KITITAS COUNTY

MEMORANDUM

TO: All Staff
FROM: Public Works Plan Review Team
DATE: December 21, 2021
SUBJECT: BL-21-00029 Pratt

RECORD OF SURVEY

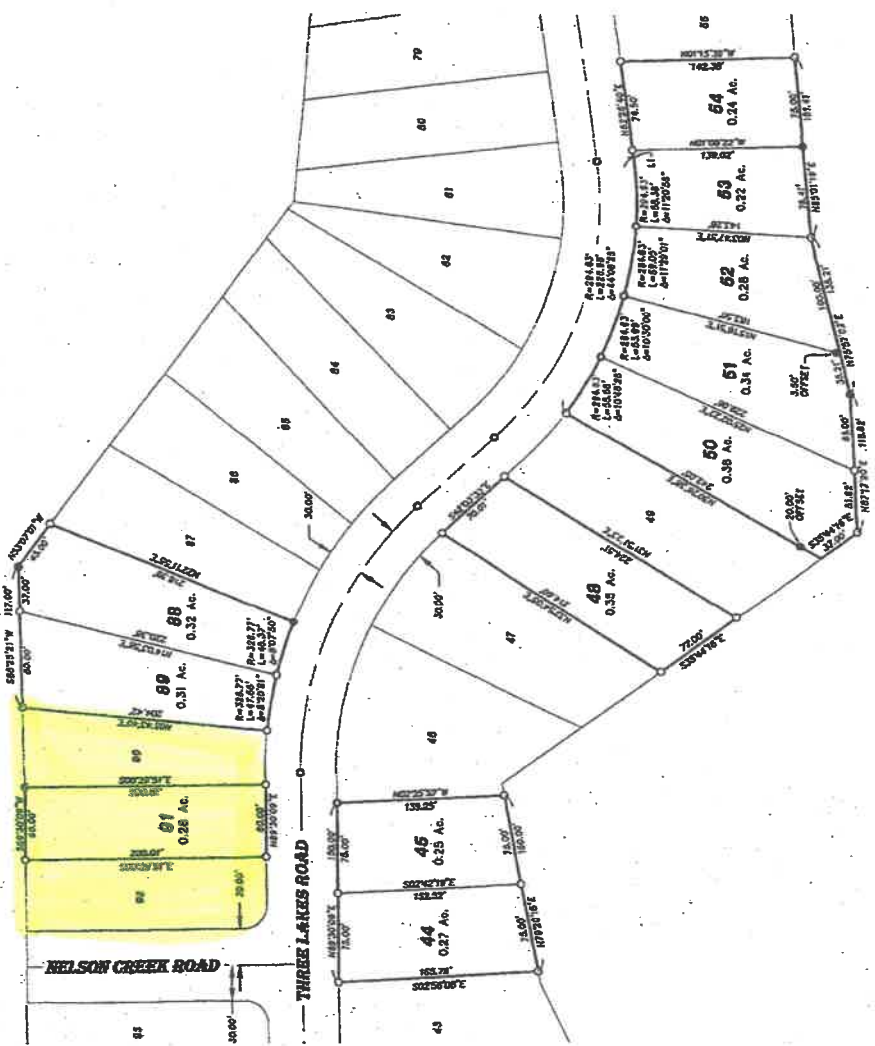
1. A revised legal description that describes the final configuration of the subject property shall be required.
2. The existing access point is not shown on the provided site map. All existing points of access shall be shown on the site plan submittal per KCC 15A.03.030.
3. A survey map for review. Any comments regarding survey will be reserved for final.
4. Show access easements on the face of the BLA.
